From: Paul Cann <Paul.Cann@arun.gov.uk>
Sent: 20 February 2023 10:40
To: Planning.Responses <Planning.Responses@arun.gov.uk>
Cc: Karl McLaughlin <Karl.McLaughlin@arun.gov.uk>
Subject: RE: Planning Re-Consultation on: Y/55/22/DOC

Application No: Y/55/22/DOC
Registered: 6th May 2022
Site Address: 10 Acre Field Grevatts Lane West Yapton
Grid Reference: 498000 101780
Category: Discharge of Condi
Description of Works: Approval of details reserved by condition imposed under Y/103/18/PL relating to conditions 8-surface water drainage, 9-discharge flows to watercourses and 10-maintenance and management of surface water drainage.

- Points 2 through 7 (inclusive) - applicant's response is acceptable to address these points. *Closed.*
- Point 8 - Further information required.
- ii. Previous comments have not been suitably addressed: *"We [ADC] do not accept the proposals, as detailed previously "Pipework should be exposed and within headwalls. To bury pipework within a gabion will prevent visual inspections for blockage being undertaken. The permeable membrane surrounding the pipe and gabion will likely silt up. Design must be maintainable". This design unnecessarily increases the risk of f

Drainage Construction Details
Proposed Basin Detail
Sheet 2 of 2

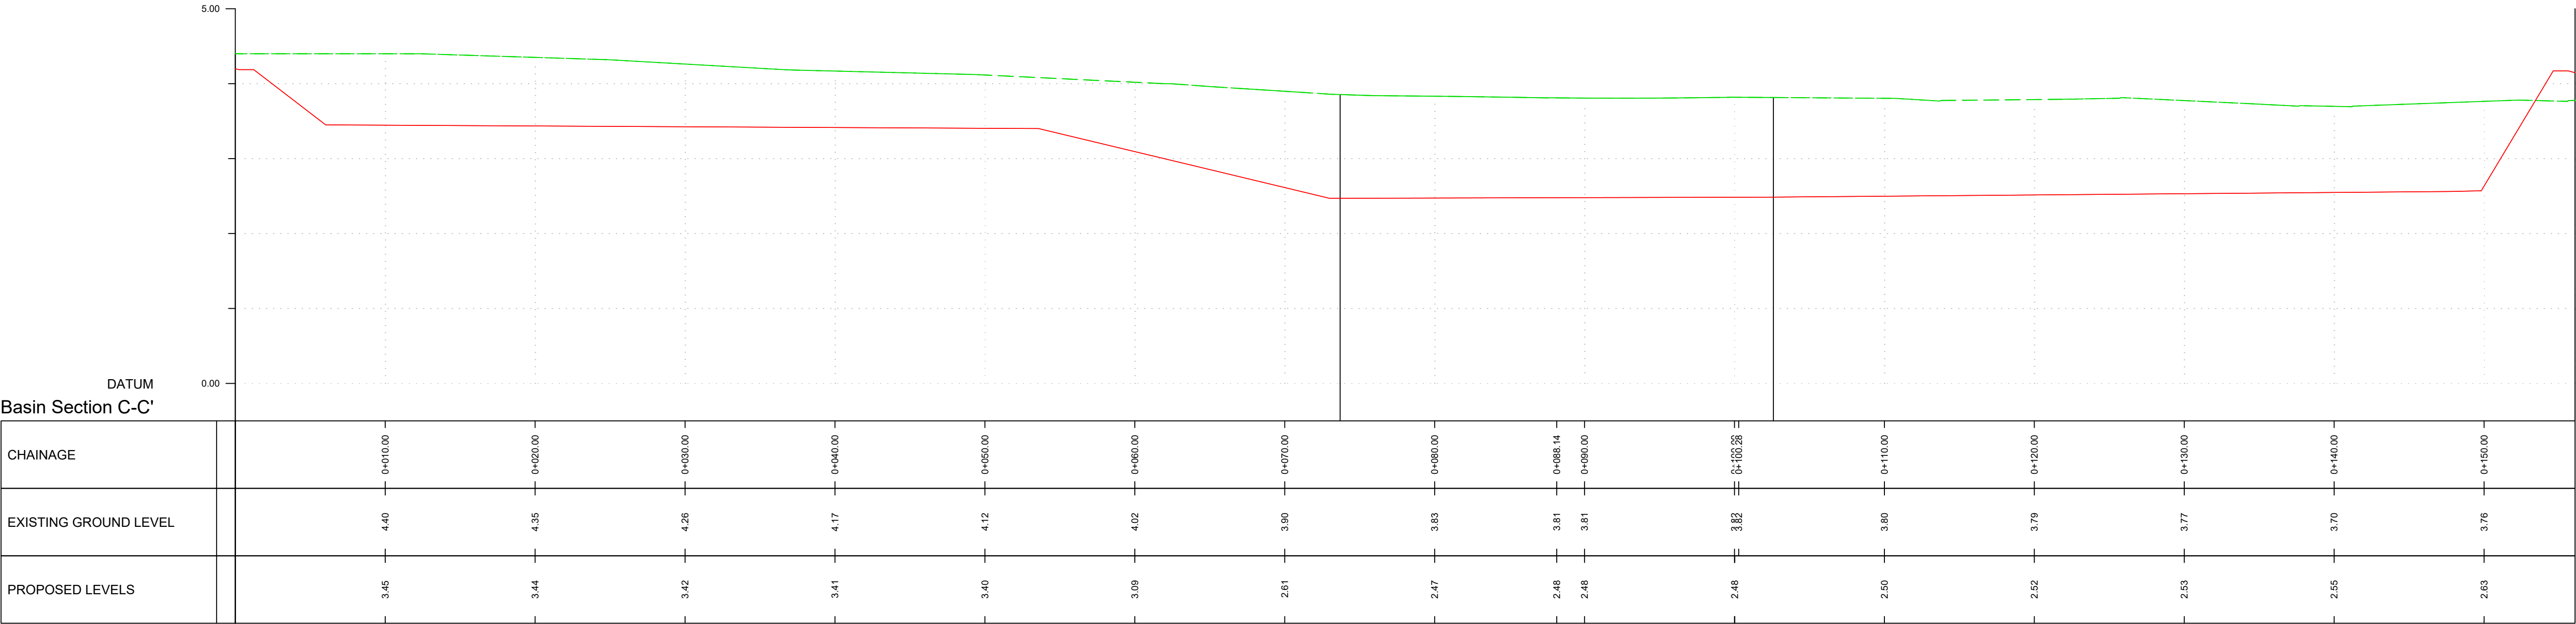
We would still urge you to reconsider this design as it adds an extra level of complexity to the maintenance of the drainage. However, should you still wish to provide the above proposals then a robust method statement of how these features will be monitored and maintained will need to be included within the Maintenance Manual. (Also see response to Condition 10 below)
